# Rezoning Transportation Analysis

Petition Number: 2023-033

Date	Description
7-26-23	First Review (IW)

SHEET NUMBER  
**RZ2-00**

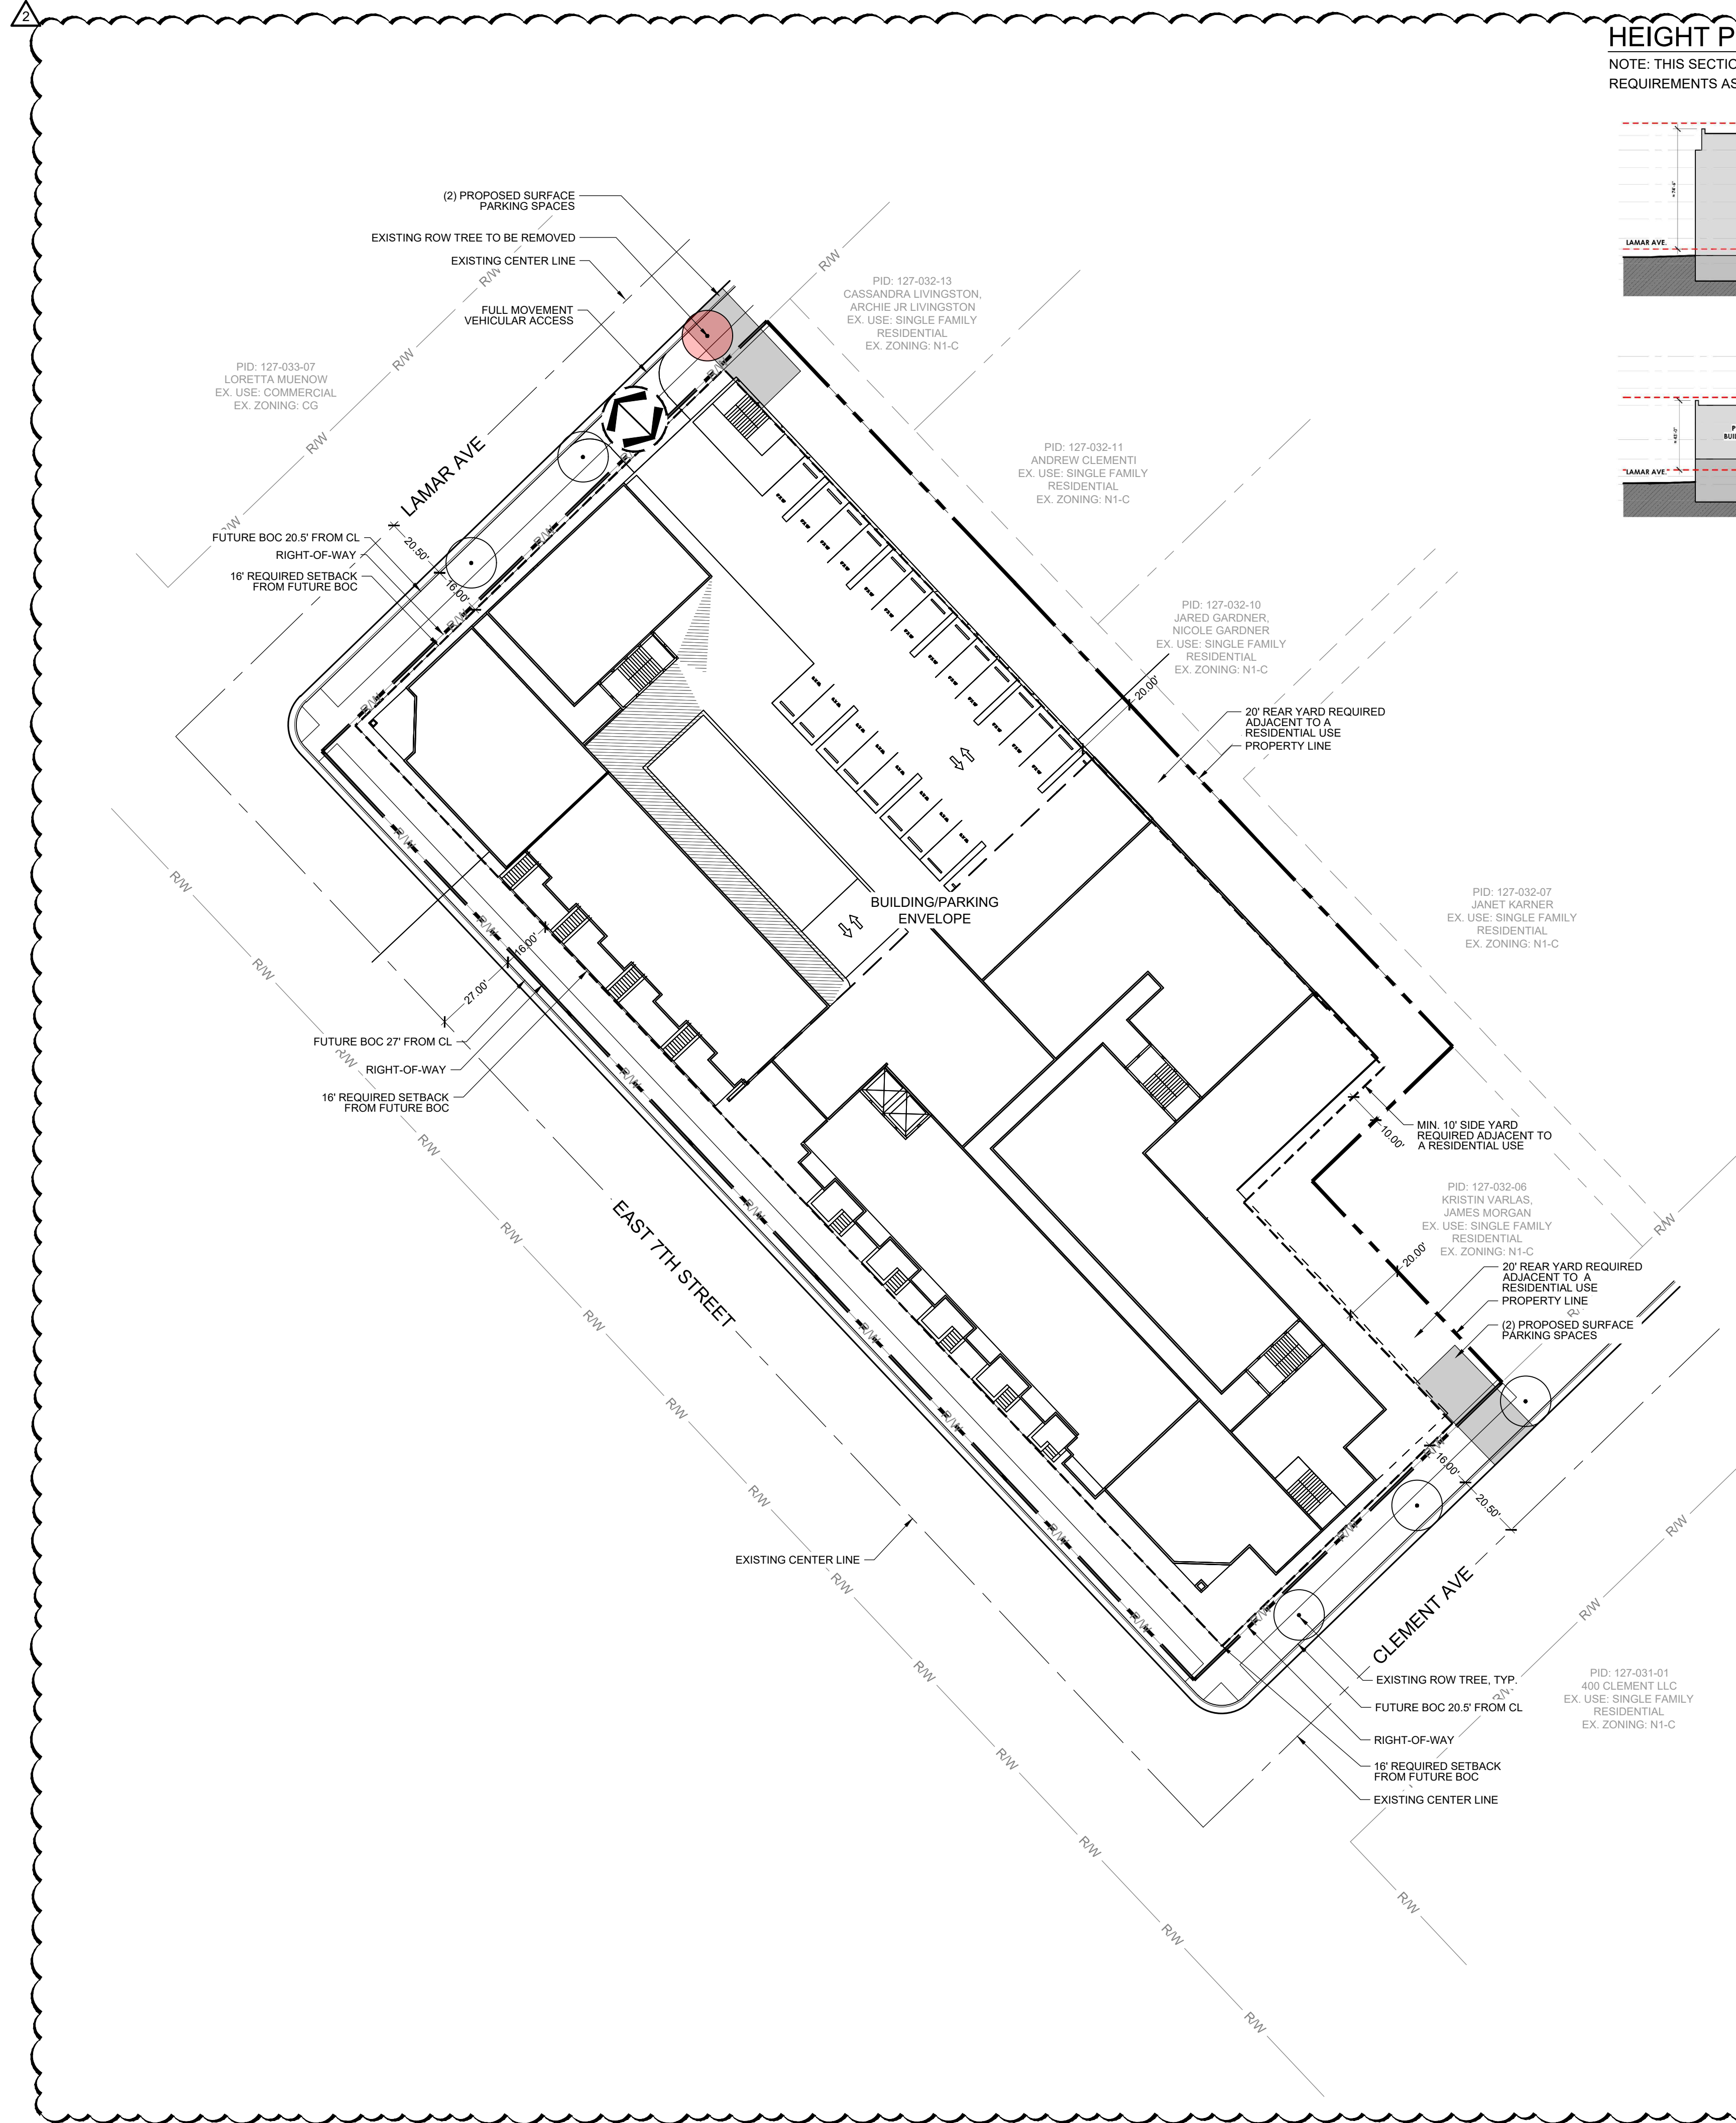
- a. **Lamar Avenue:** The future location of curb and gutter is in its existing location.
- b. **Clement Avenue:** The future location of curb and gutter is in its existing location.
- c. **East 7<sup>th</sup> Street:** Location of future back of curb and gutter to be moved to 27 feet from roadway centerline to accommodate the Charlotte Streets Map with a roadway typical section of 2+ Avenue, Buffered/separated bike lanes.

Label and dimension the curb and gutter from the centerline for each road on the site plan.

4. Revise site plan and conditional note(s) to commit to dedicate 45' of right-of-way from the E. 7<sup>th</sup> Street road centerline. The site plan shall label and dimension the right-of-way from the road centerline.

5. Revise site plan and conditional note(s) to commit to construct an 8-foot planting strip, and 8-foot sidewalk on Lamar Avenue, E. 7<sup>th</sup> Street and Clement Avenue per Chapter 19 & Chapter 20. The site plan shall label and dimension both items from the back of curb and gutter or edge of pavement.

8. CDOT requests that the petitioner revise site plan and conditional note(s) to commit to upgrading the rapid flashing beacon pedestrian crossing at Clement Ave and E. 7<sup>th</sup> Street.
